Development Facilitation Team (DFT) – Review Comments

DRB Project No: PR-2021-004968 Date: 06/14/2023 Agenda Item: #2 Zone Atlas Page: C-10

Legal Description: [TRACT B-1-A & B-2-A, LA CUENTISTA SUBDIVISION]

Application For: SD-2023-00108 – FINAL PLAT (DHO)

Plat for
La Cuentista
 Subdivision, Phase I
 Being Comprised of
 Tracts B-1-A and B-2-A,
 La Cuentista Subdivision
 City of Albuquerque
 Bernalillo County, New Mexico
 March 2023

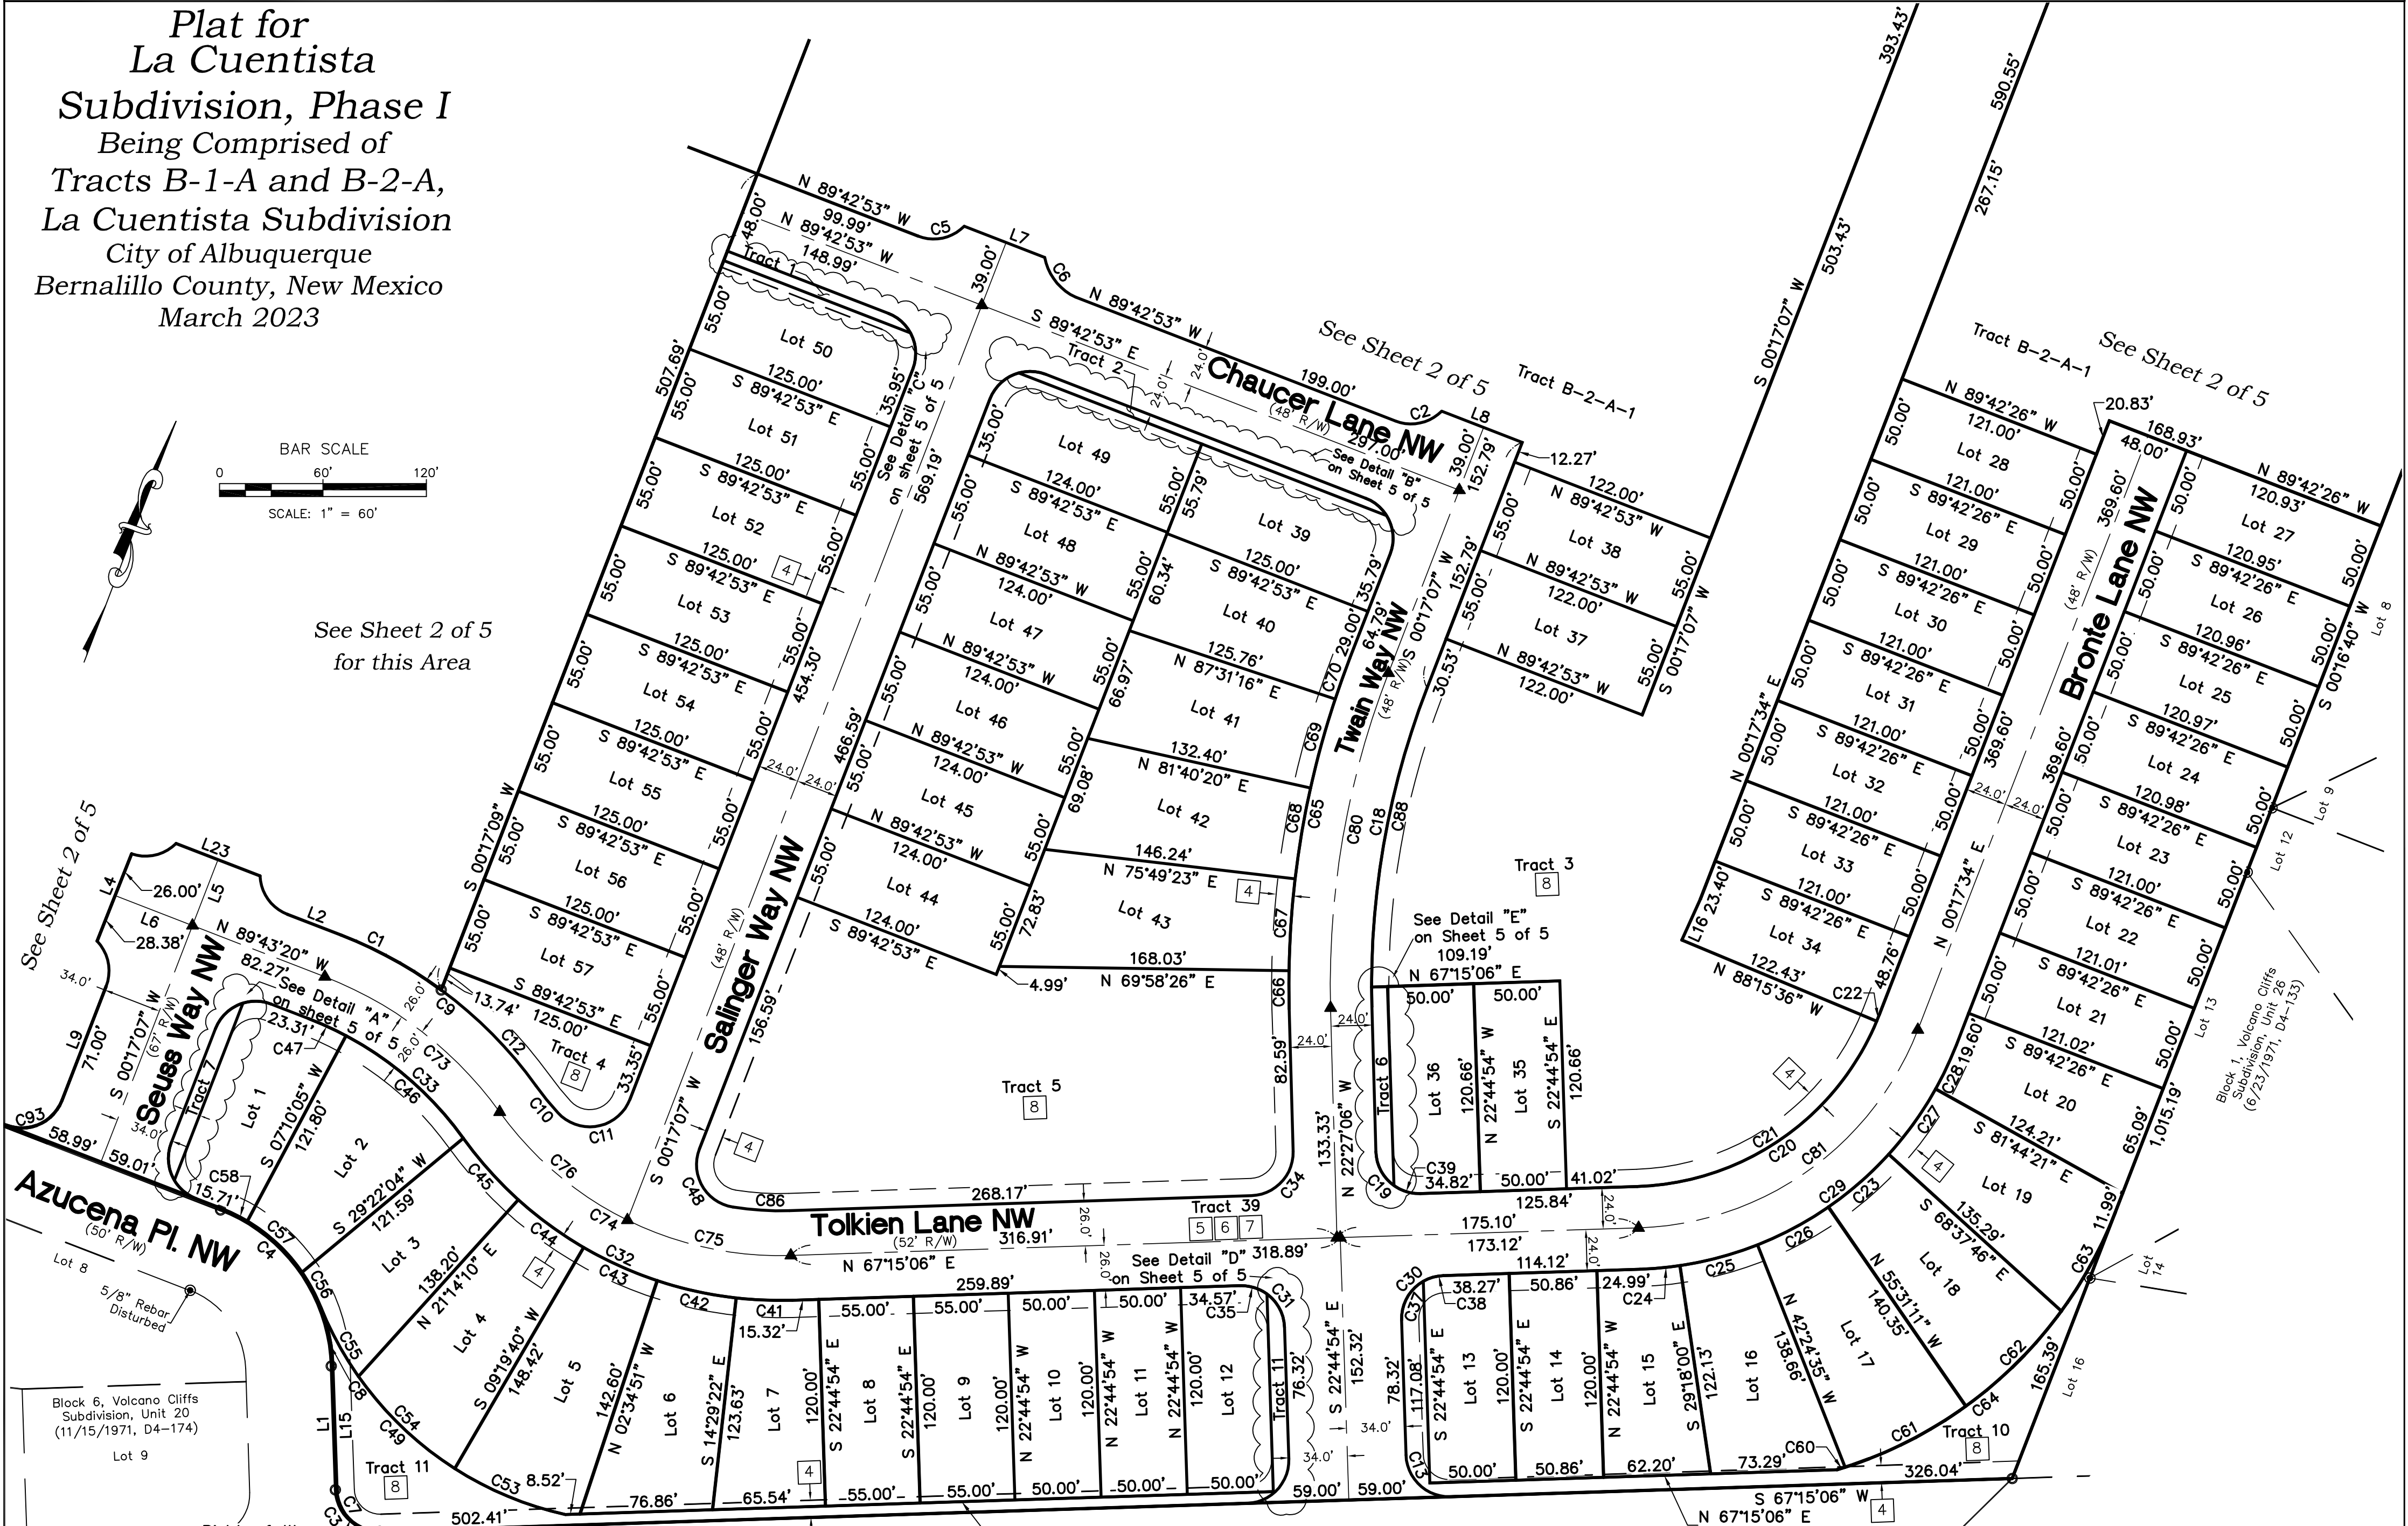
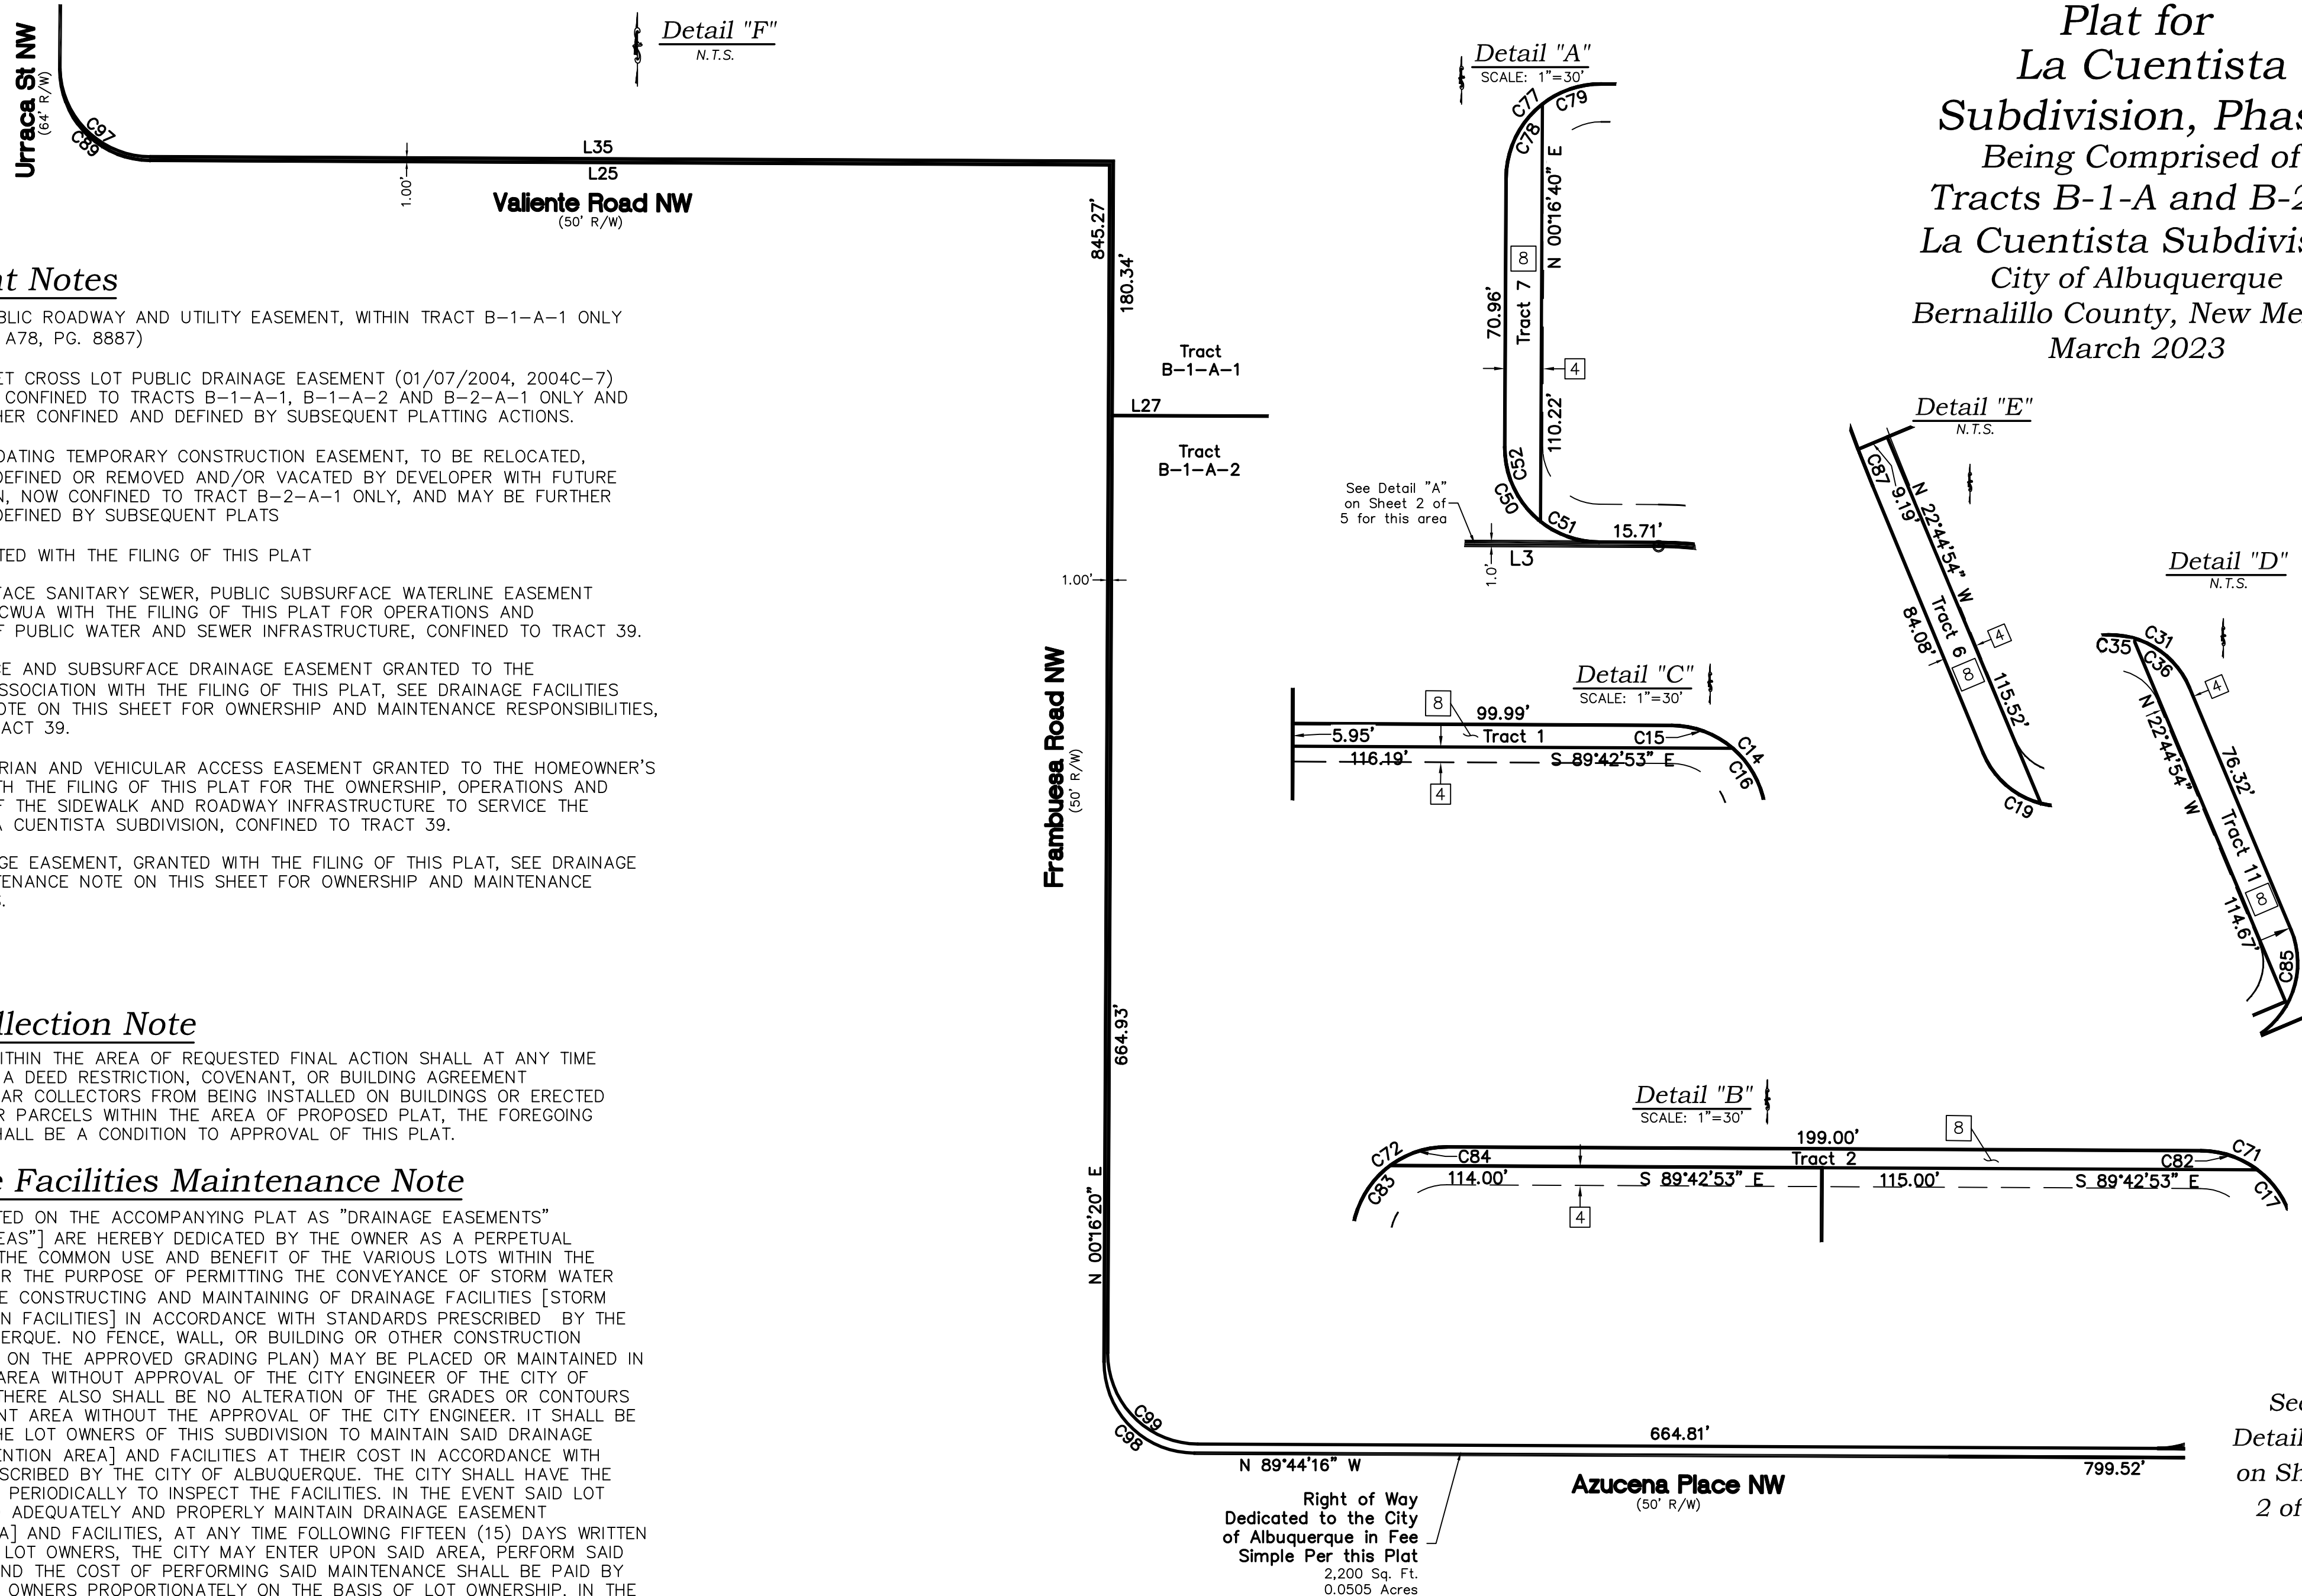
- Please clarify if this Final Plat is a 57 lot-phase (Phase 1) which is part of a four-phase development comprising a total of 248 lots.
- Please clarify if item 8 of Tract 3 in the Plat (Sheet 3) is the same pond of the Wall Exhibit sheet.
- Under the Waiver Notes section on Sheet 2 of the Plat, two of the DPM sections which Waivers were approved for are mislabeled as “DMP.” They must be corrected to “DPM.”
